From: Nichols, Chris - E&E
Sent: 18 September 2020 15:10
To: Bob Neville <Bob.Neville@cherwell-dc.gov.uk>
Cc: DC Support <DC.Support@cherwell-dc.gov.uk>; Cllr George Reynolds <George.Reynolds@Oxfordshire.gov.uk>
Subject: 20/02060/F: The Stables, Main Street, Great Bourton.
Importance: High

Planning application:	20/02060/F
Location:	The Stables, Main Street, Great Bourton, Cropredy, OX17 1QU.
Description:	Change of use of land to a mixed use for the keeping of horses (existing) and as a residential caravan site for 4no gypsy families. Each with two caravans (including no more than 4no static caravans / mobile homes) together with the laying of hardcore. rear extension.
Type:	Full
Case Officer:	Bob Neville

# SITE LAYOUT PLAN

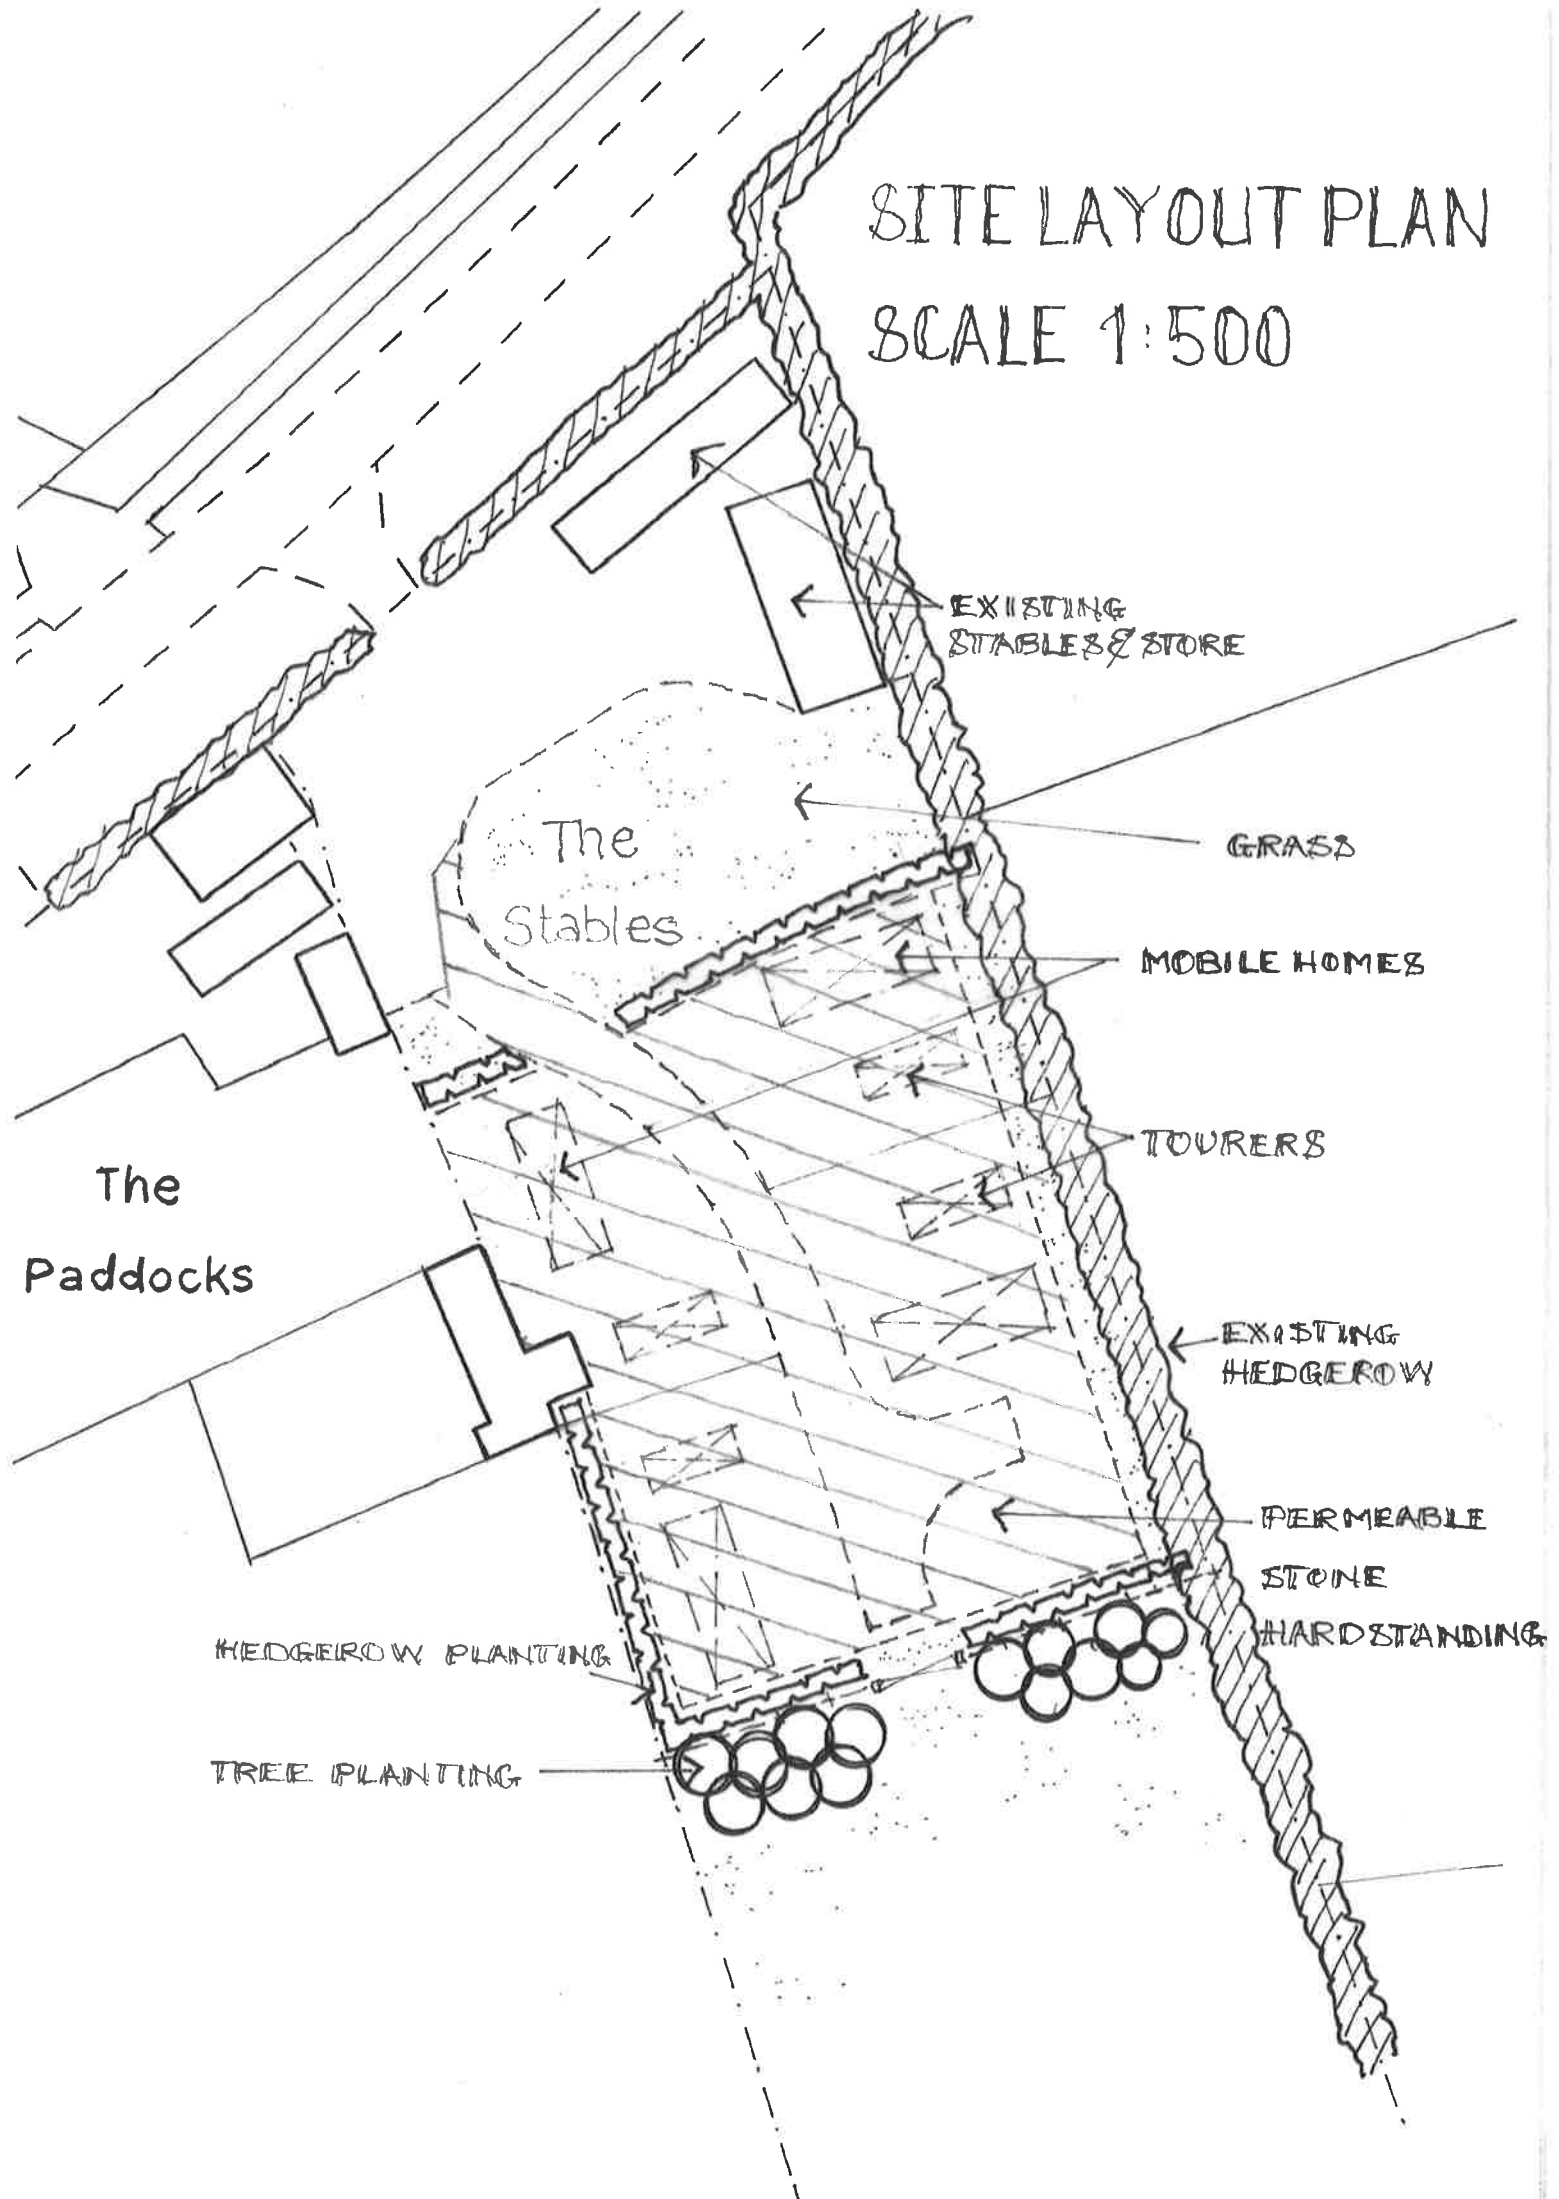
The plans do not show provision for car parking. This can be provided in discharge of a condition of planning permission.

D18 Plan of car parking provision
